Application No.: 02DRB-00666 (P&F)

Project Name: LOS ANGELES INVESTORS

**13. Project #1001921
Application # 02DRB-00666
Lands of Los Angeles Investors**

PLAT OF
OF
LOT E-1-A
LANDS OF LOS ANGELES INVESTORS
WITHIN
PROJECTED SECTION 14, T.11N., R.3 E., N.M.P.M.
ELENA GALLEGOS GRANT
CITY OF ALBUQUERQUE
BERNALILLO COUNTY, NEW MEXICO
MARCH, 2002

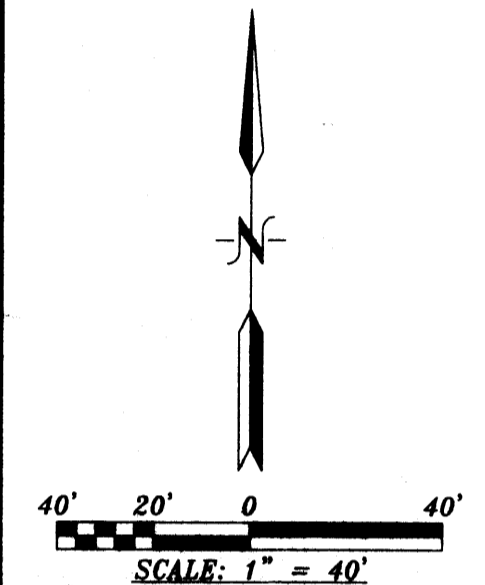
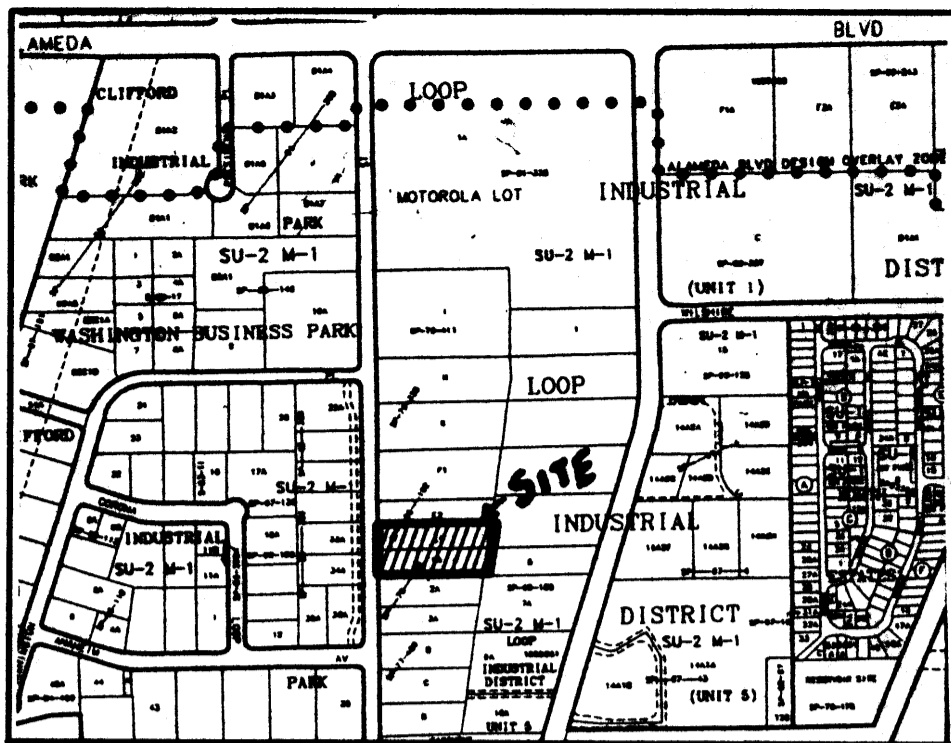
- TRANSPORTATION: Verify that there is 10' of R/W between face of curb
- UTILITIES: Add Standard Note II. Label 20' public S&S easement to property line
- CITY ENGINEER / AMAFCA: _____
- PARKS / CIP: _____
- PLANNING (Last to sign): See comments

2. Add the zoning classification to the *Subdivision Data* section on the plat.
 3. Property Management's signature is required only on plats that vacate public right-of-way or dedicate parkland. Otherwise, the signature line may be marked "n/a".

4. Planning signs last. All other signatures must be obtained prior to requesting final sign-off by Planning.
 5. Include the Project # and Application # on the plat.
